CITY OF ALBUQUERQUE

Re: Copper Pointe (Holiday Inn Express)
10501 Copper Pointe Way NE, 87123
30-Day Temporary Certificate of Occupancy
Transportation Development Final Inspection
Engineer's/Architect's Stamp dated 8-8-18 (K21D009H3)
Certification dated 12-18-19

Ernie Gomez,
Plan Checker, Planning Dept.
Development Review Services

ARCHITECTURAL SITE PLAN
SCALE: 1" = 20'

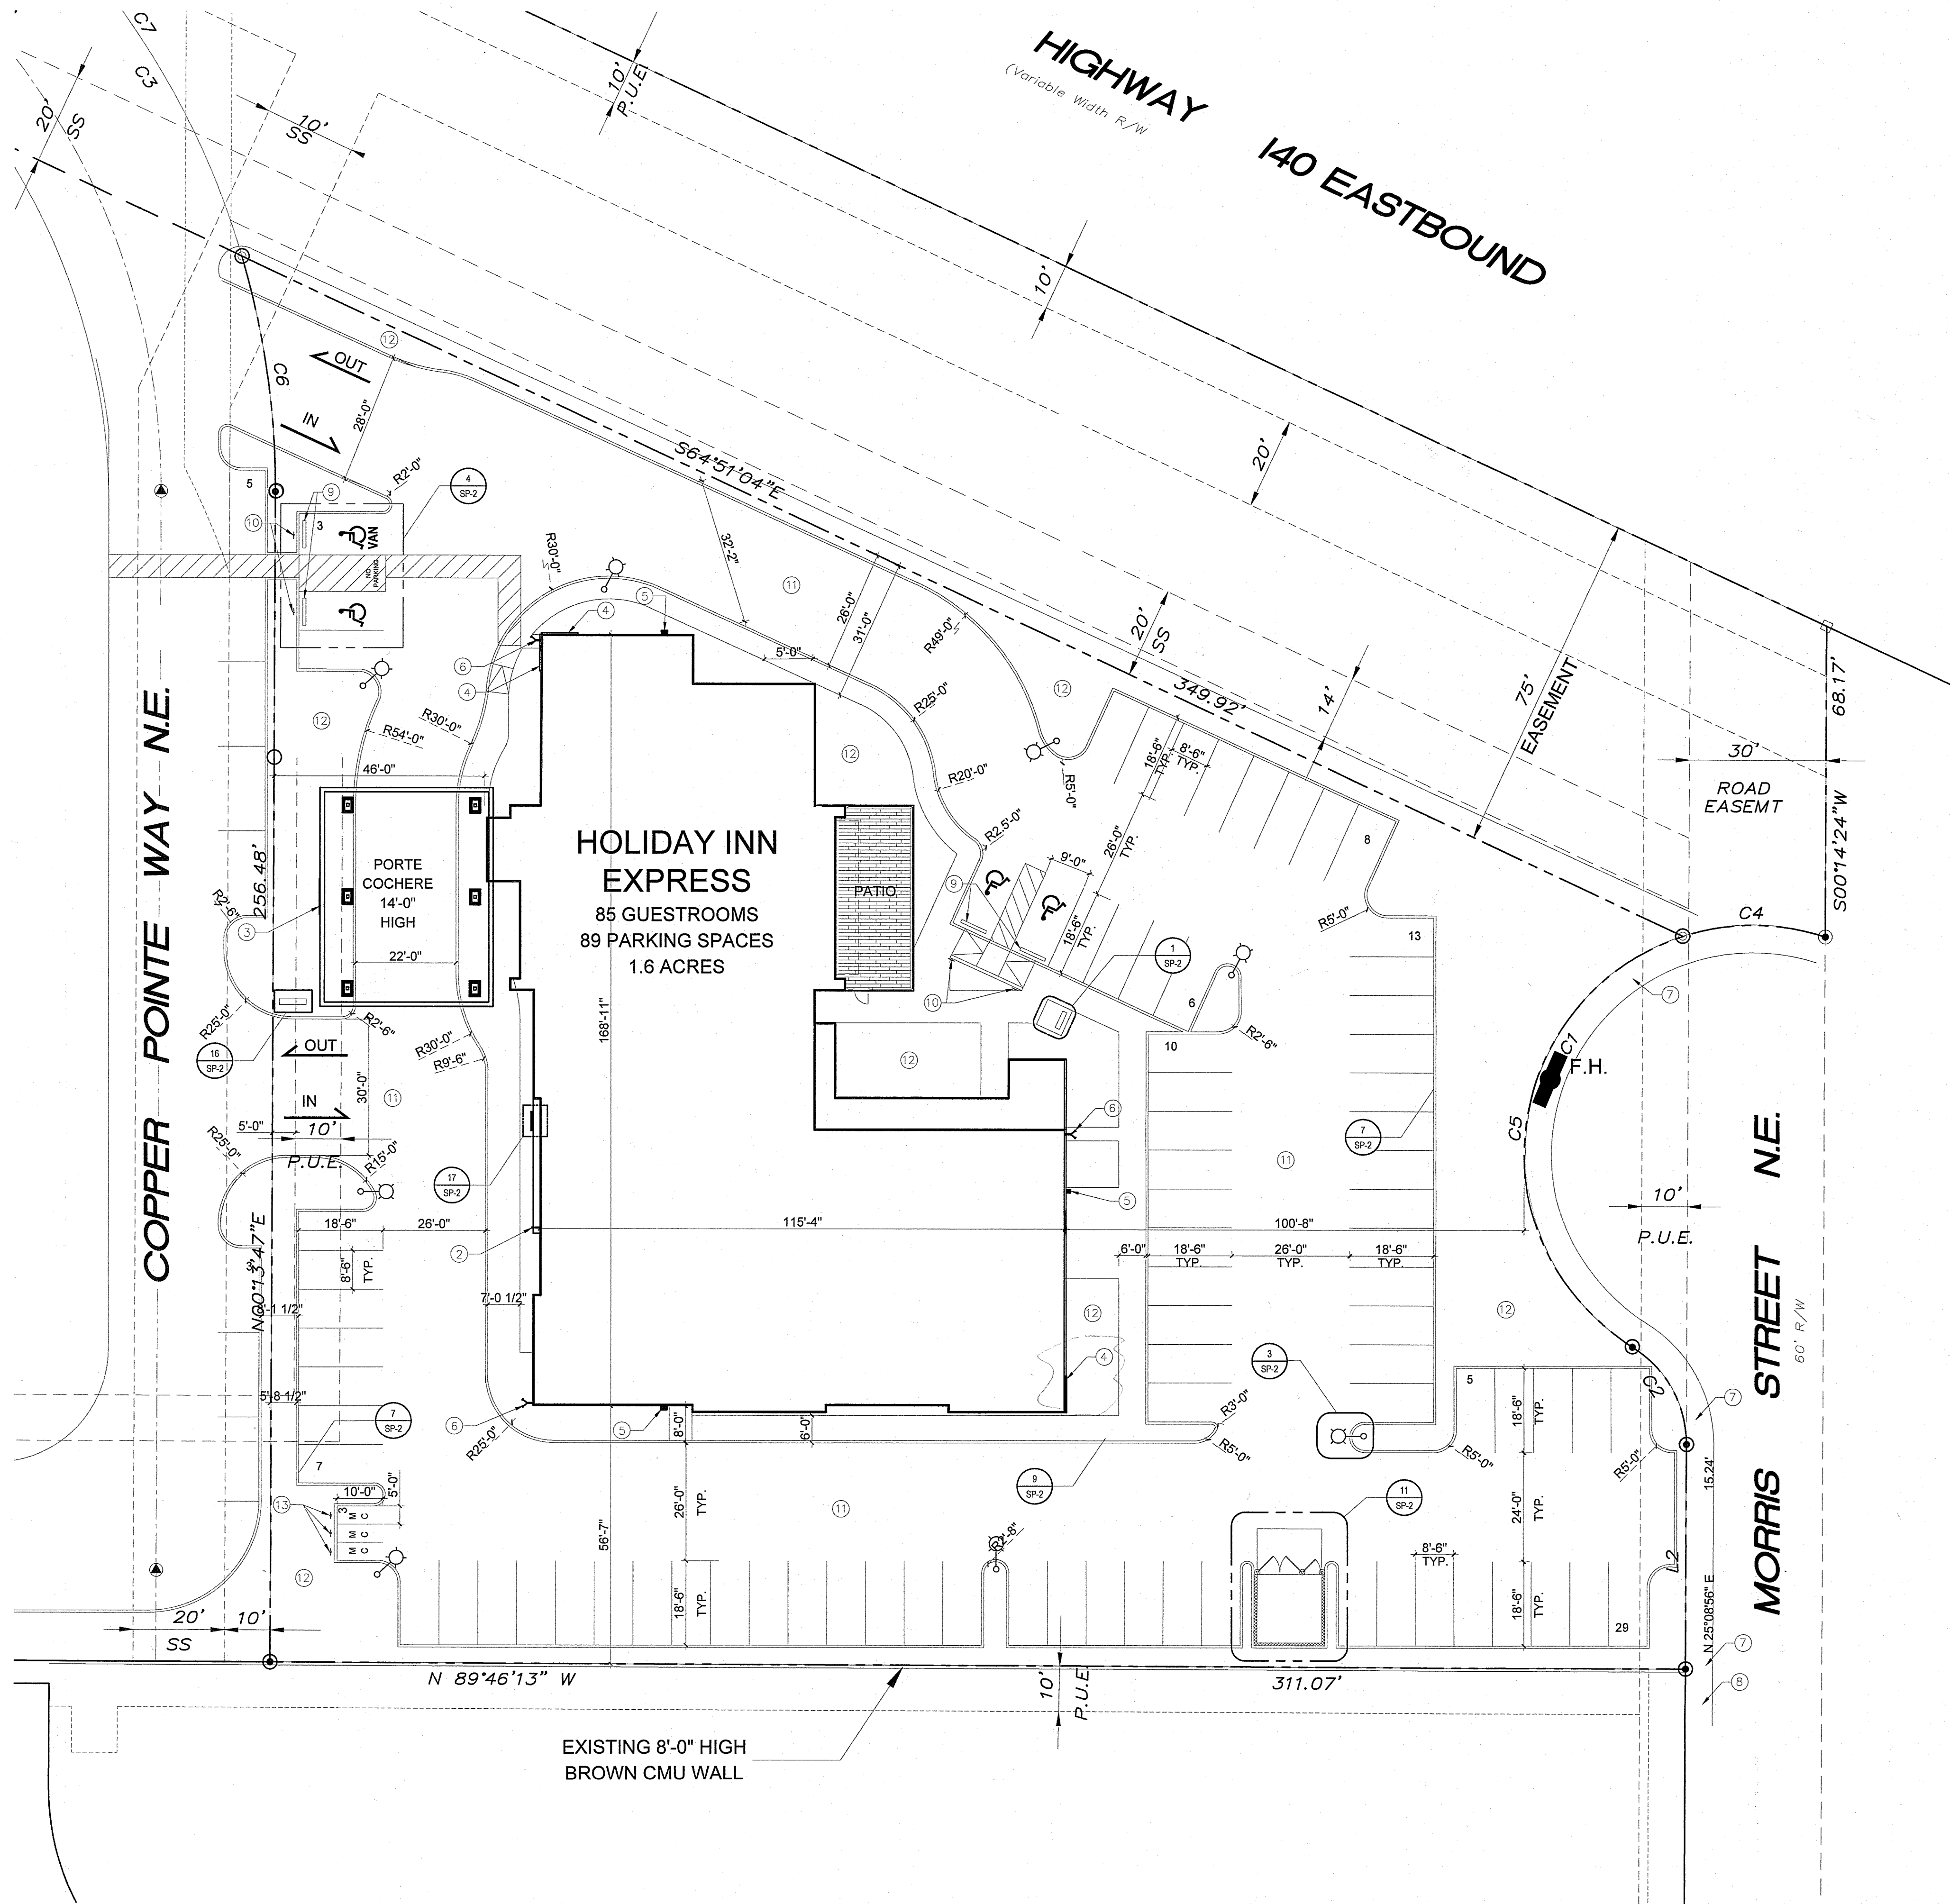
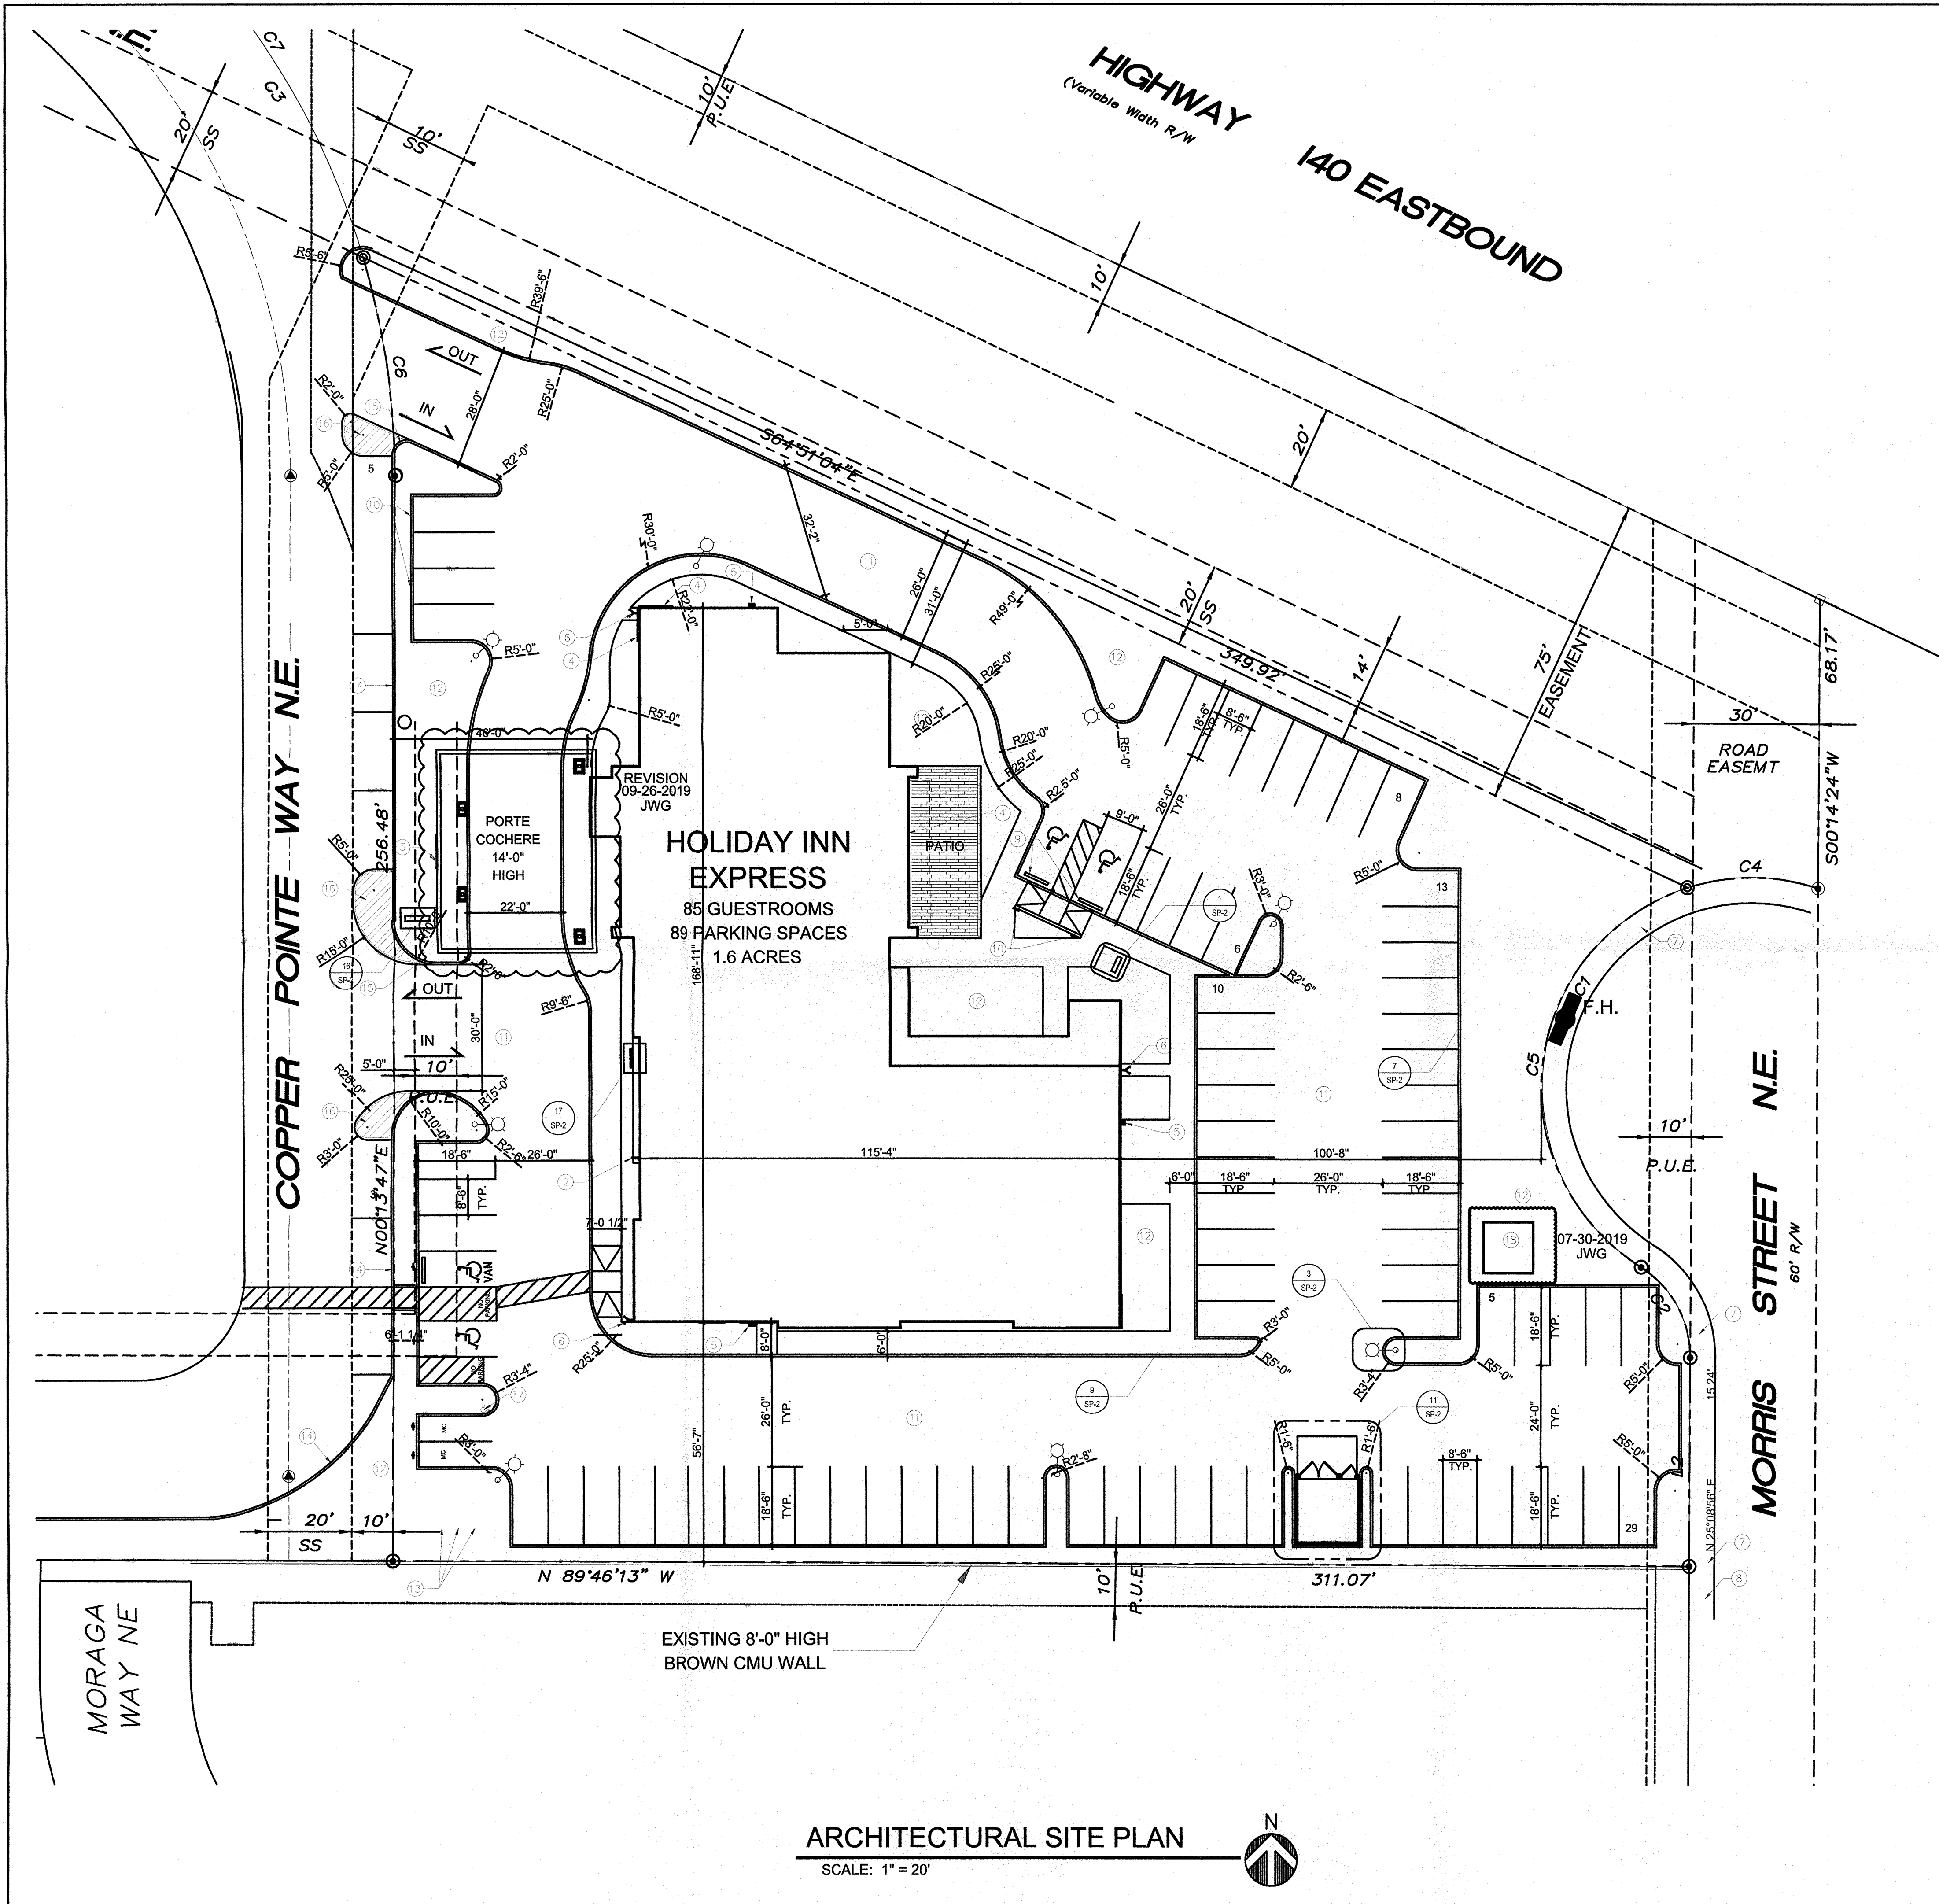
- Please resubmit the Approved DRB plan reflecting the relocation of the ADA stalls & access aisle and ADA pathway from public sidewalk to building entrance.
- Please stamp the certification letter when resubmitting
- Per the IDO, a 6 ft. wide ADA accessible pedestrian pathway is required from the public sidewalk to the building entrances. Please clearly show this pathway and provide details. (ADD ADA compliant ramp at relocation of ADA stalls and access aisle)(Restripe a 6ft wide access to building entrance. Current stripe is 4 foot wide)
- Please remove debris and construction materials from site.

1. The approved and stamped DRB Site Plan for Building Permit with changes drawn in red.
2. Transportation Certification letter on either the plan or applicants letterhead.
3. A Drainage Transportation Information Sheet (DTIS)
4. Send an electronic copy of your submittal to PLNDRS@cabq.gov.
